**CITY OF MERCER ISLAND**

May 10, 2018

RE: Review Comments for File No. CAO17-010 – Hou Critical Areas Determination  
4825 E Mercer Way, Mercer Island, WA 98040; King County Tax Parcel # 216200-0070

**CRITICAL AREAS MITIGATION PLAN
 PROPOSED SITE PLAN, IMPACTS & MITIGATION PLAN
 HOU PROPERTY
 MERCER ISLAND, WA**

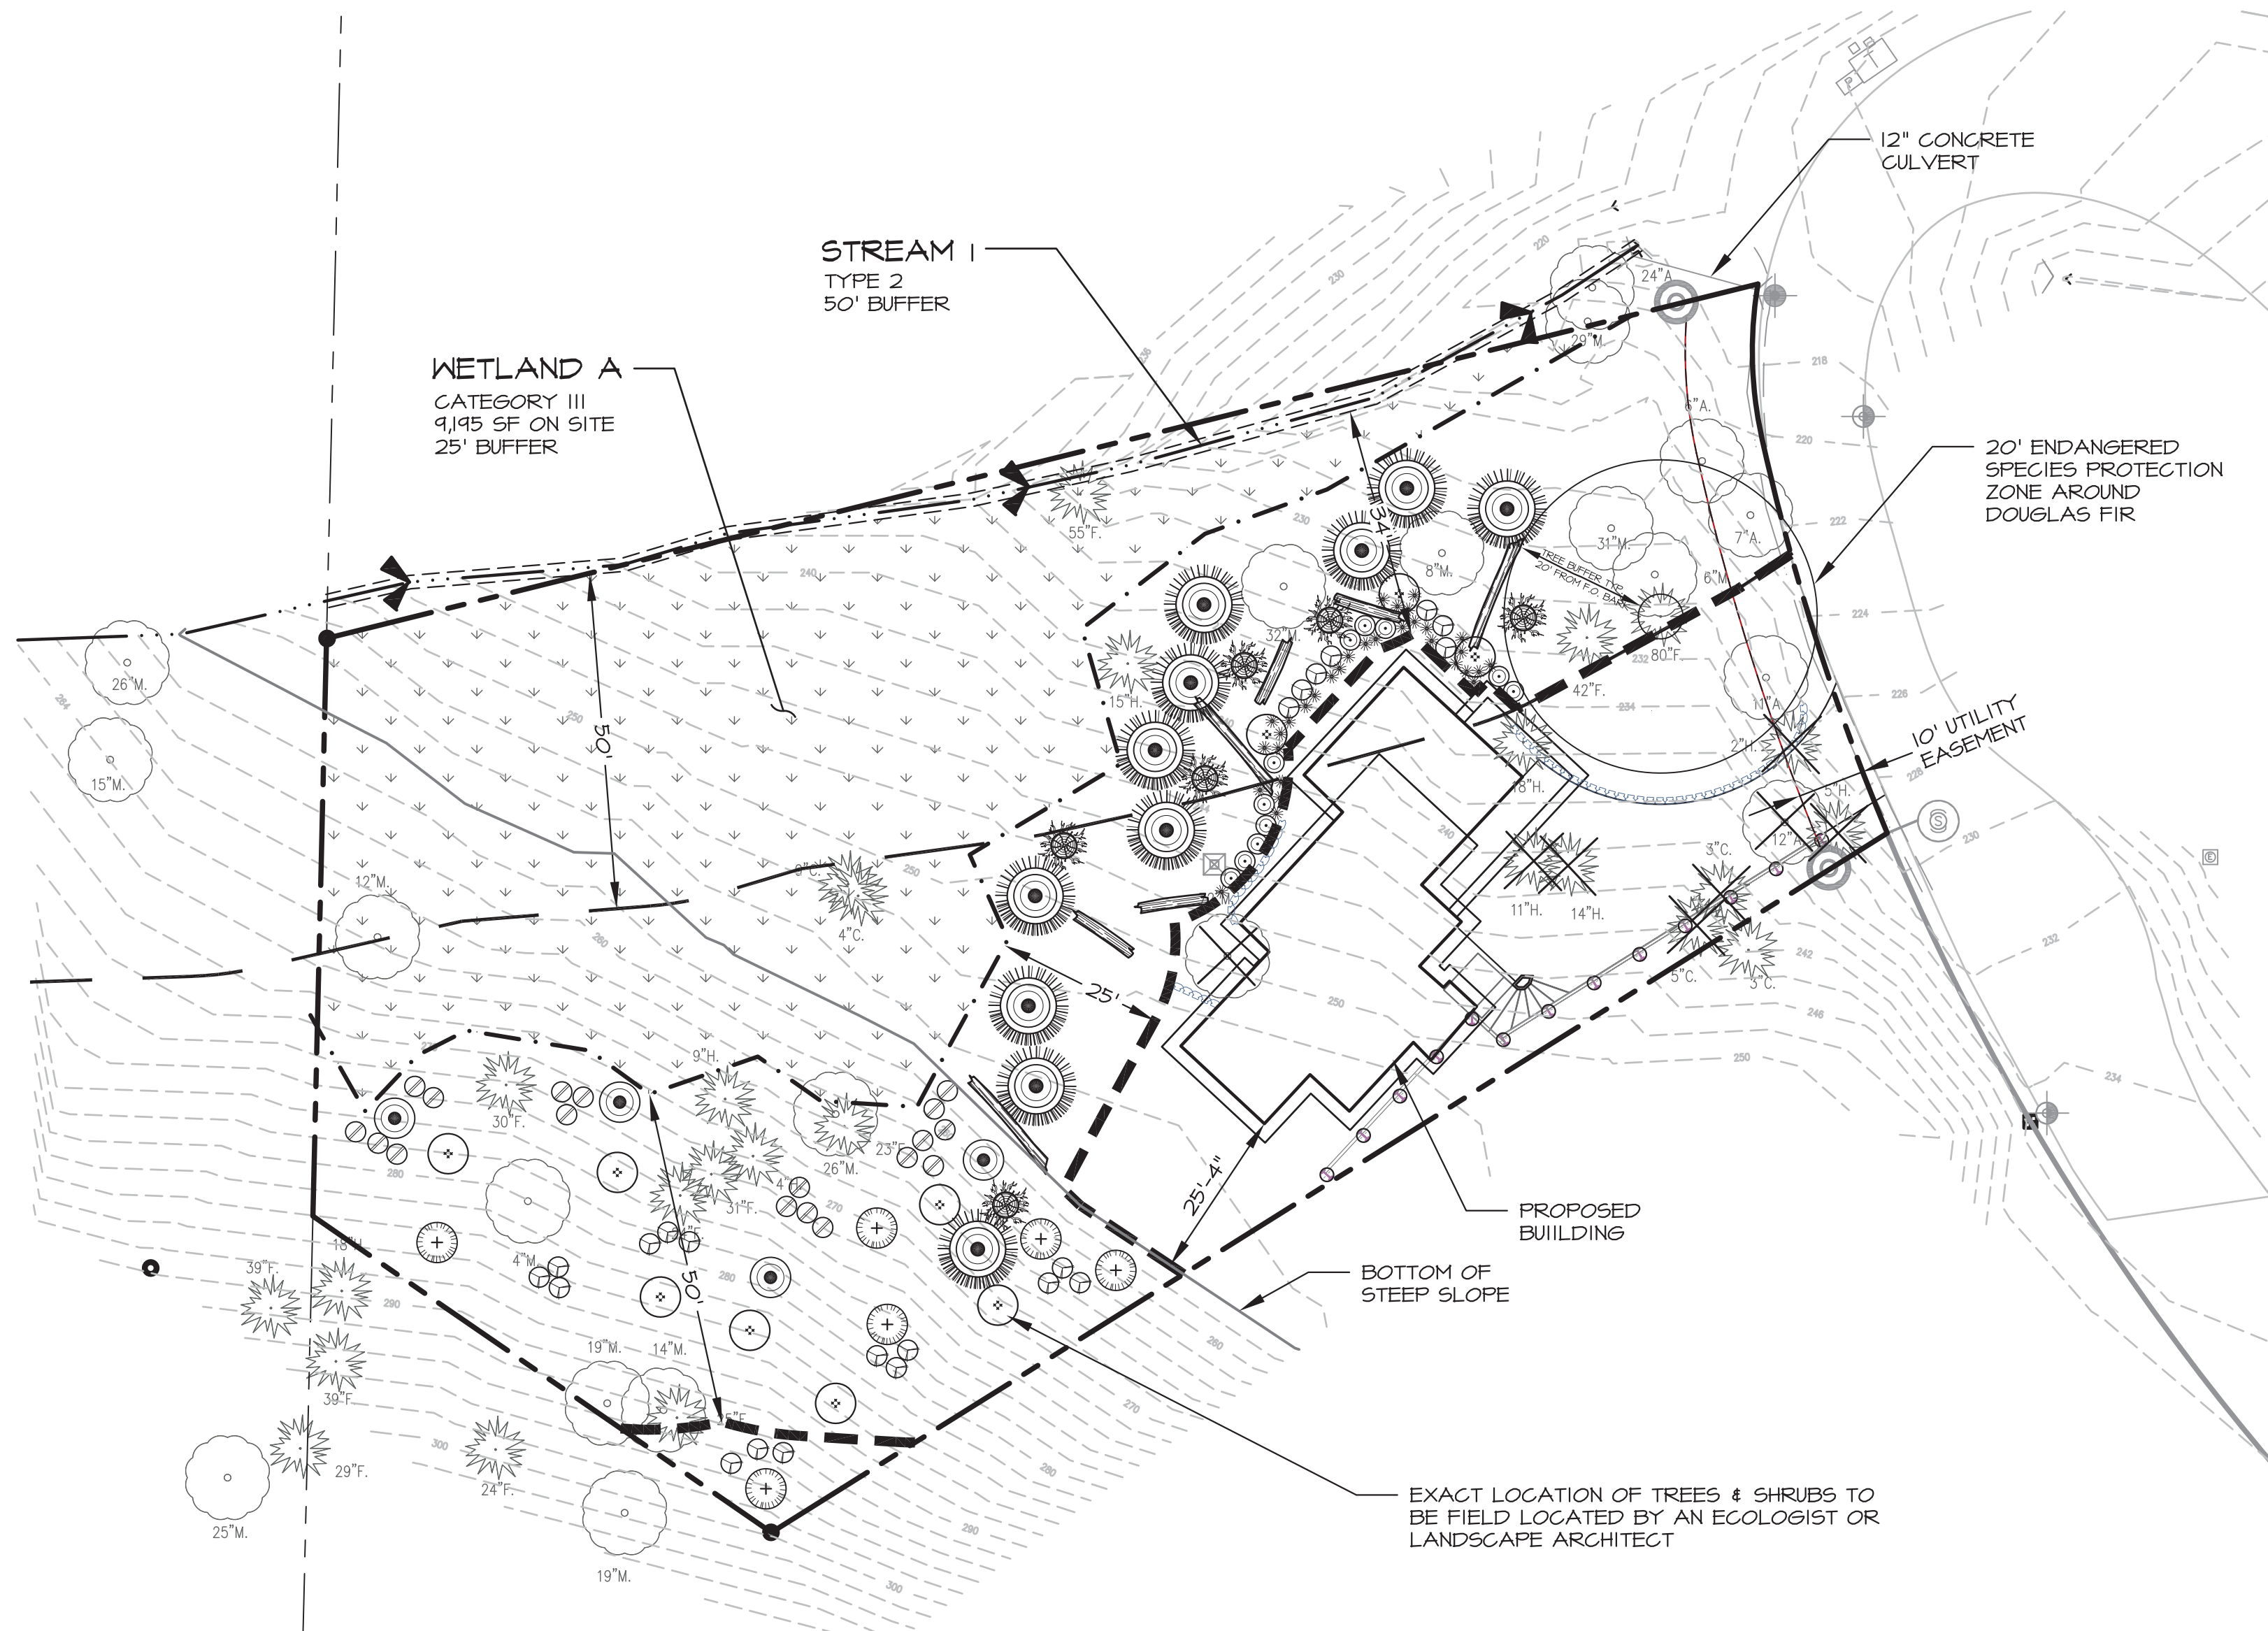
1. Please indicate on the project plans where drainage from the proposed house and driveway will go ( Will it be directed to the stream? Will it be directed to the ditch?).

2. It appears the exterior of the proposed house is too close to the proposed buffer. Identify the area of construction on the plans and determine what construction and future home maintenance activities will occur and how these can occur without disturbing the buffer. There will likely need to be more space between the proposed home and the proposed buffer than shown on the plans to accommodate these activities without disturbing the buffer. Please provide the needed setback from the buffer on the plans.
